**ANGEL PLACE
LEVEL 8, 123 PITT STREET
SYDNEY NSW 2000**

RESPONSE TO REQUEST FOR INFORMATION - SSD-8571481

This submission of additional information has been prepared by Urbis on behalf of Technical and Further Education (**TAFE**) NSW in respect of the State Significant Development (**SSD**) application (SSD-8571481) for an educational facility at 2-44 O'Connell Street, Kingswood (**the project**).

DWG #	DA0103	REV	E
SCALE @ A1	As indicated

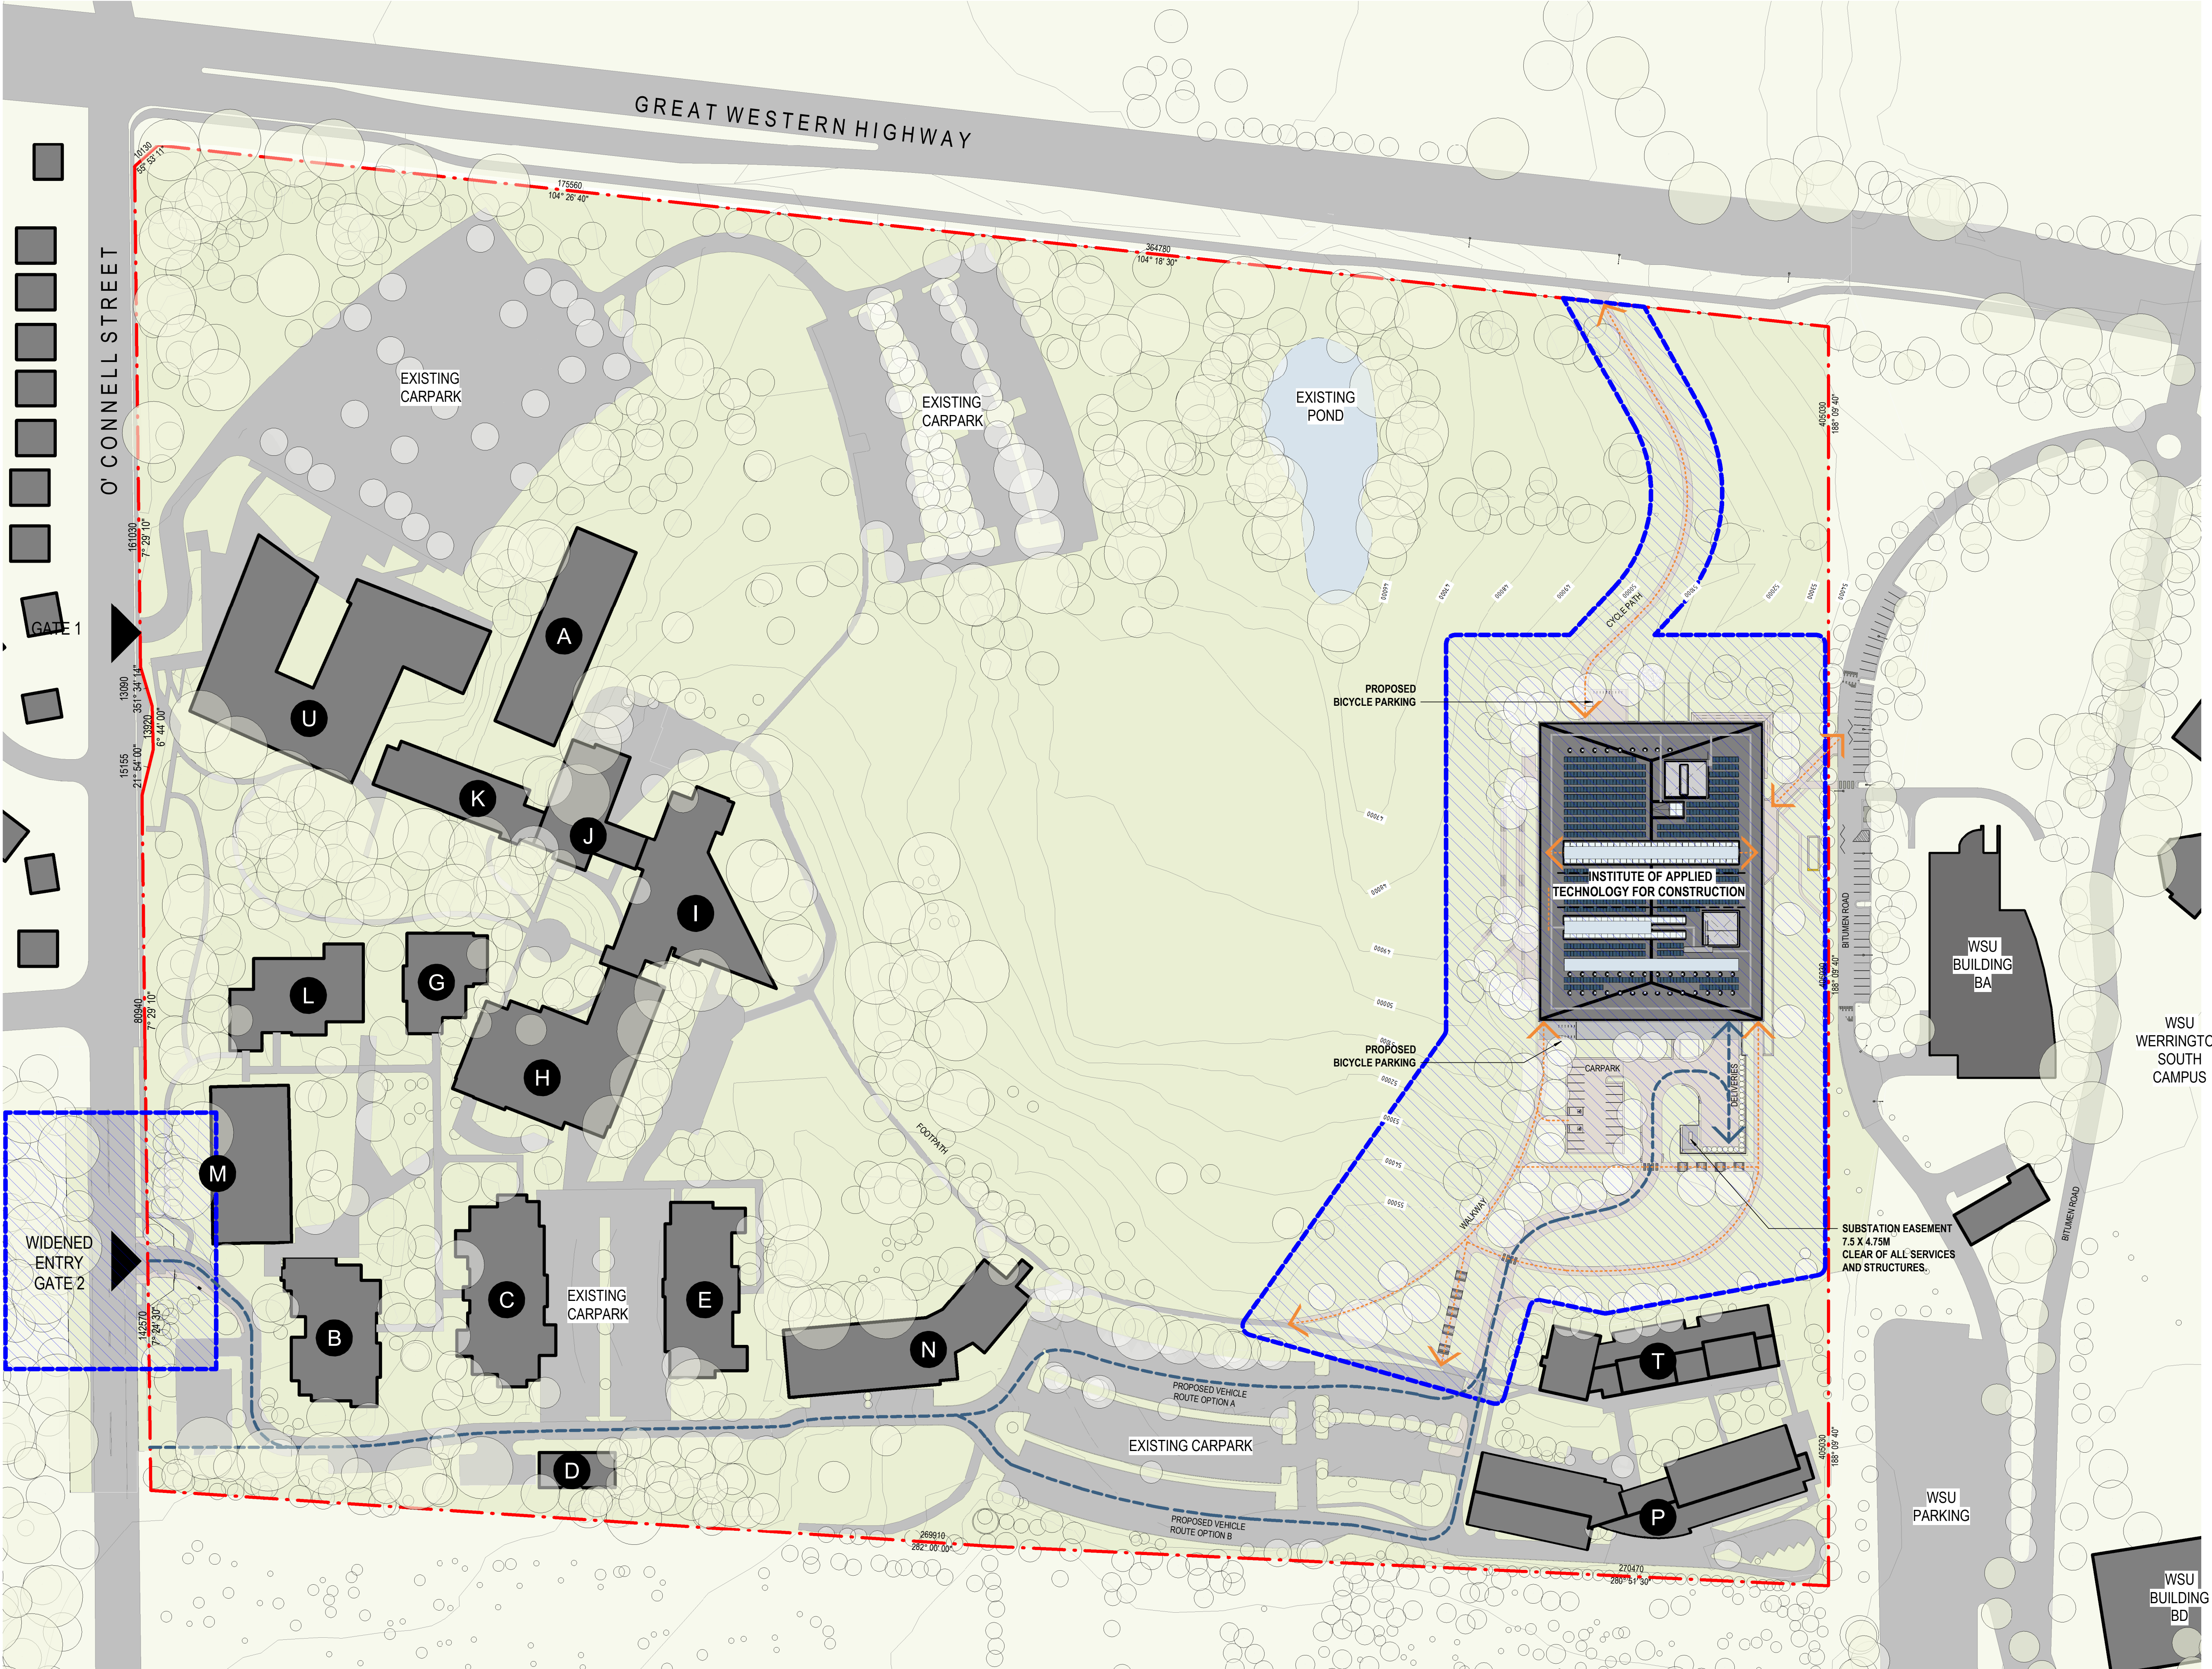
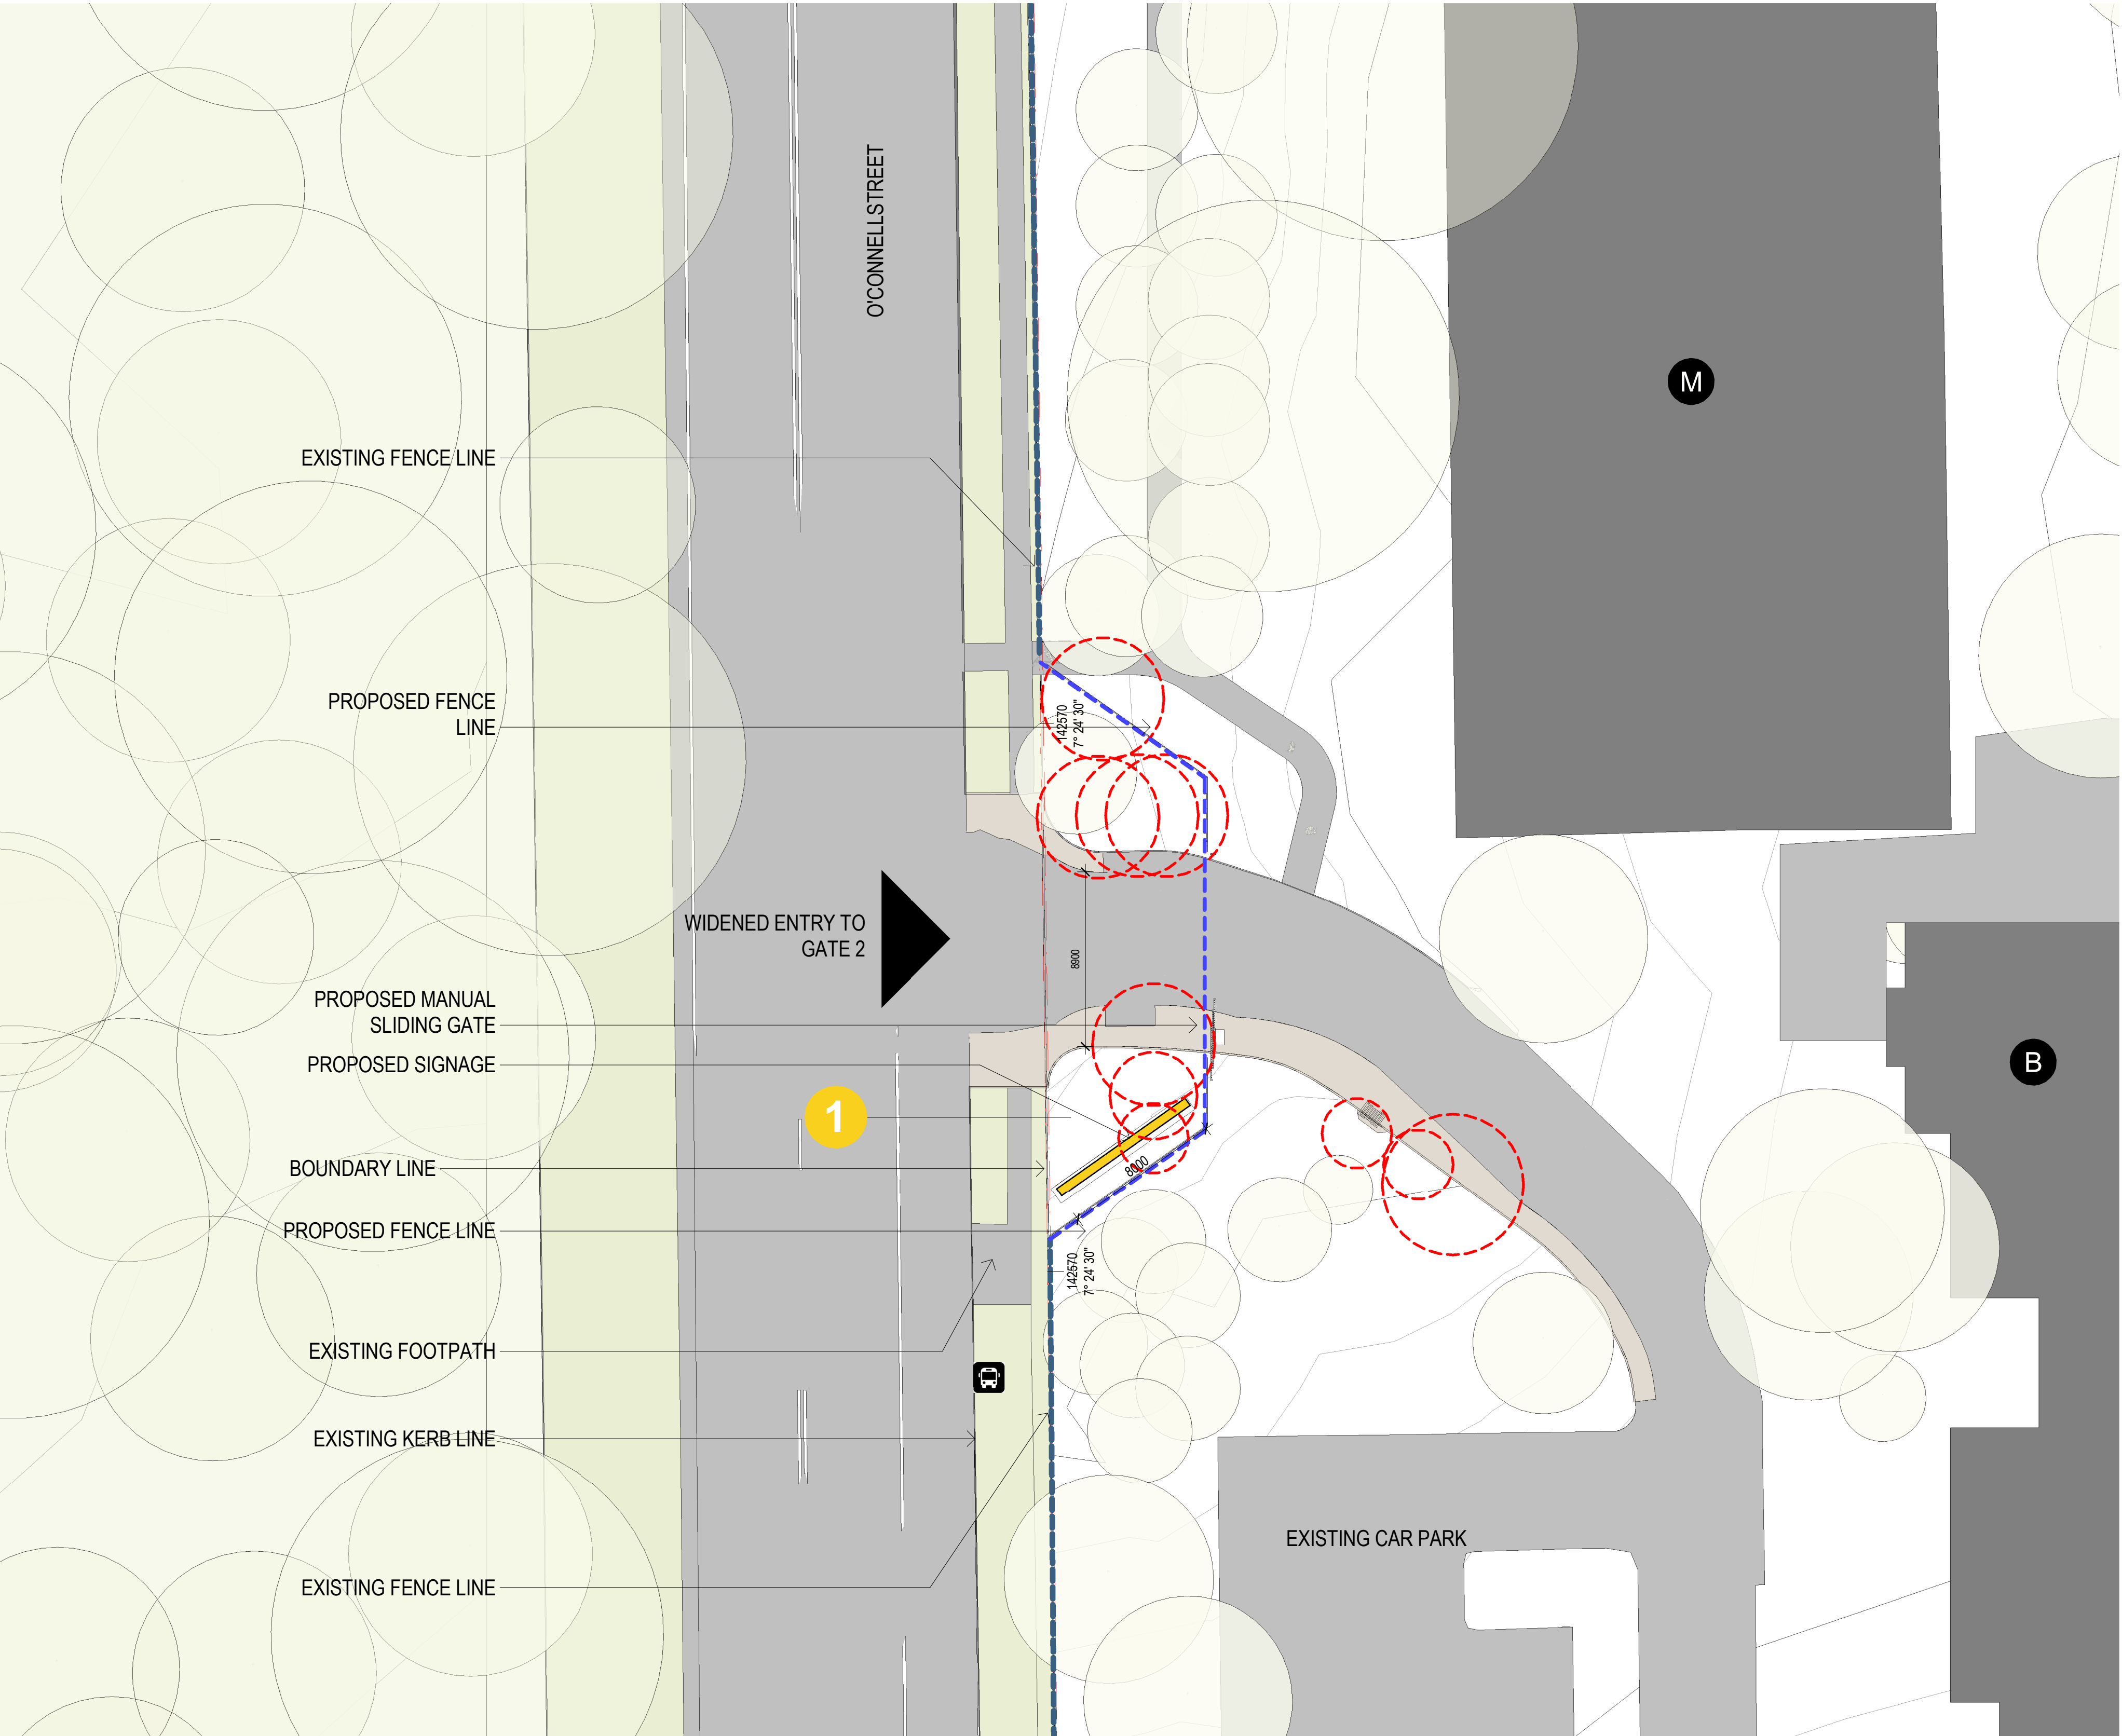
| Item | Agency Comment | Proponent Response |
|---|---|---|
| 3 | <i>confirm the number of secure bicycle parking spaces to be provided, and clearly identify the relocated spaces (northern elevation) on the revised plans.</i> | <ul style="list-style-type: none"> ▪ Proposed bicycle spaces: 26 secure bicycle spaces, including 10 spaces on the north side and 16 spaces on the south side. ▪ Spaces will be protected by passive surveillance and a CCTV system and have been designed to comply with AS 2890.3. ▪ Refer to Architectural Plans at Attachment A, specifically plan reference DA 103 Revision E. |
